**Application Reference:** 2025/0923.

**Location:** 16 First Avenue, Royston, Barnsley, S71 4DA.

This application seeks planning permission for the erection of a two-storey wraparound extension to the side (north) and rear (east) and the erection of a first-floor extension above the existing dwelling to form a two-storey dwellinghouse.

PLANS & ELEVATIONS

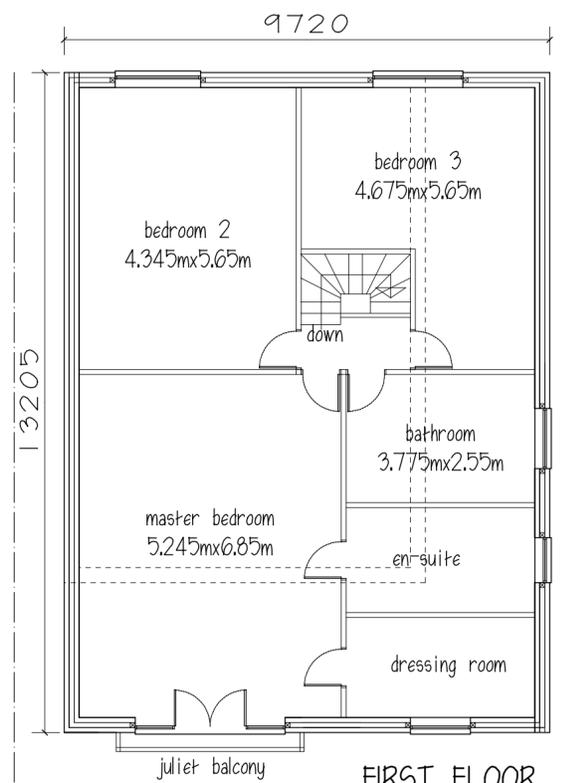
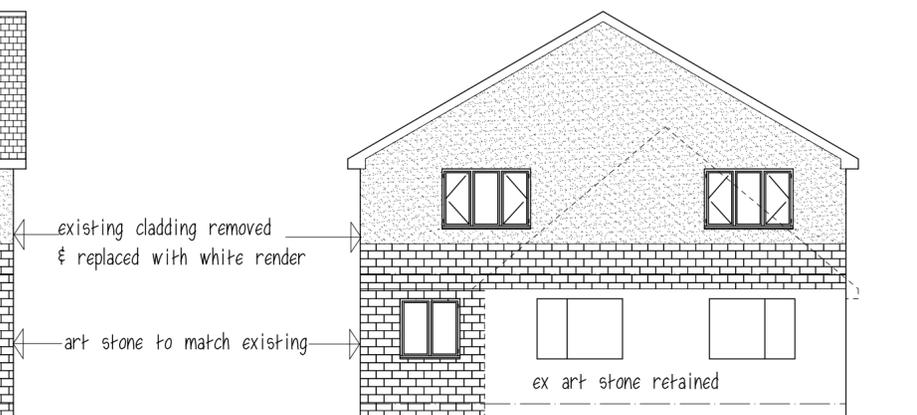
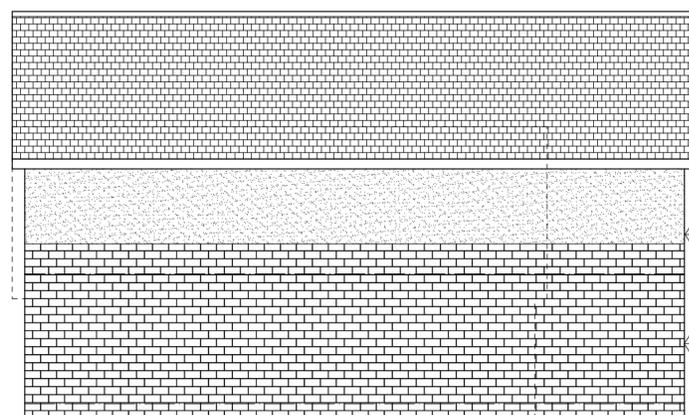
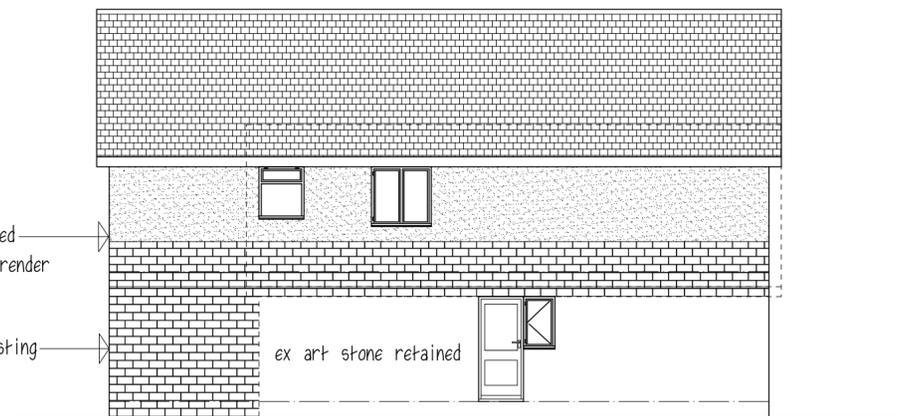
During the application process, the proposal was amended to re-balance the use of stonework and render, re-align apertures on the rear (east) elevation, and to replace a first-floor balcony with a Juliet balcony, better reflecting the Council's adopted design guidance in the House extensions and other domestic alterations SPD

Plans & Elevations Rev. A received 4<sup>th</sup> December 2025.

PLANS & ELEVATIONS

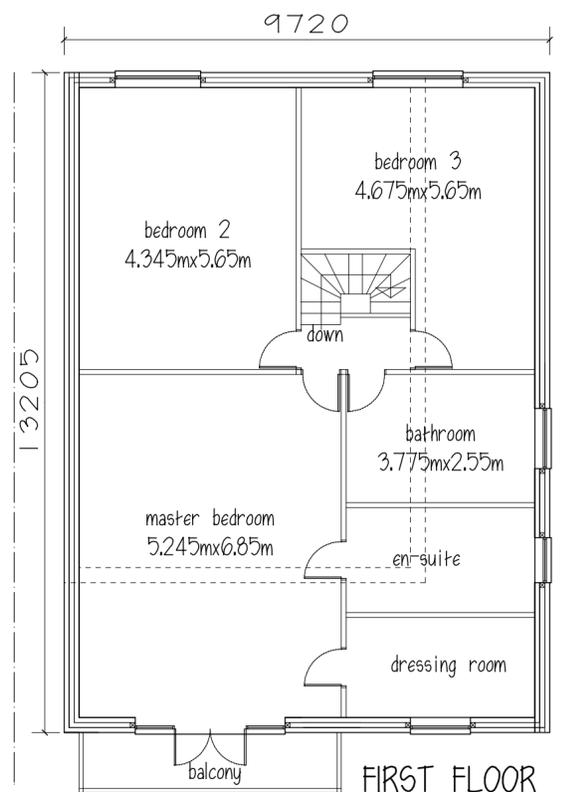
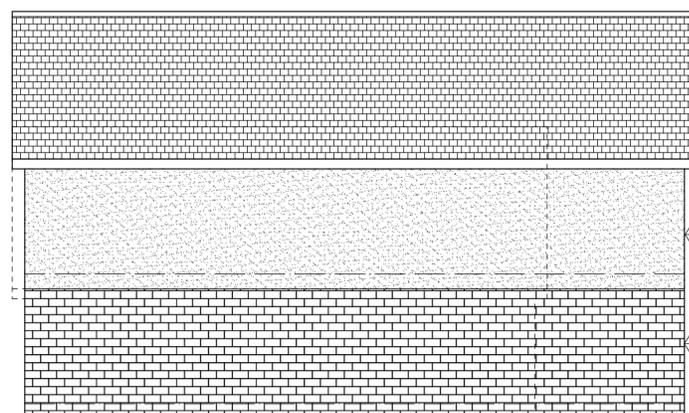
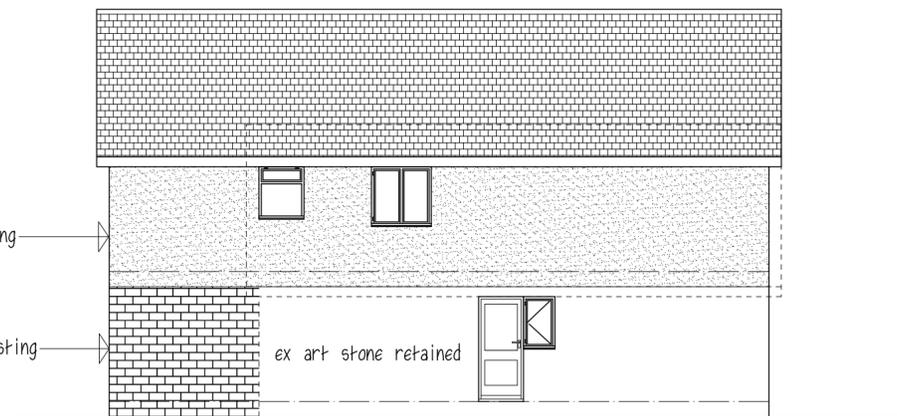
- Re-balancing the stonework and render.
- Re-align apertures on rear (east) elevation.
- Replacing a first-floor balcony with a Juliet balcony.
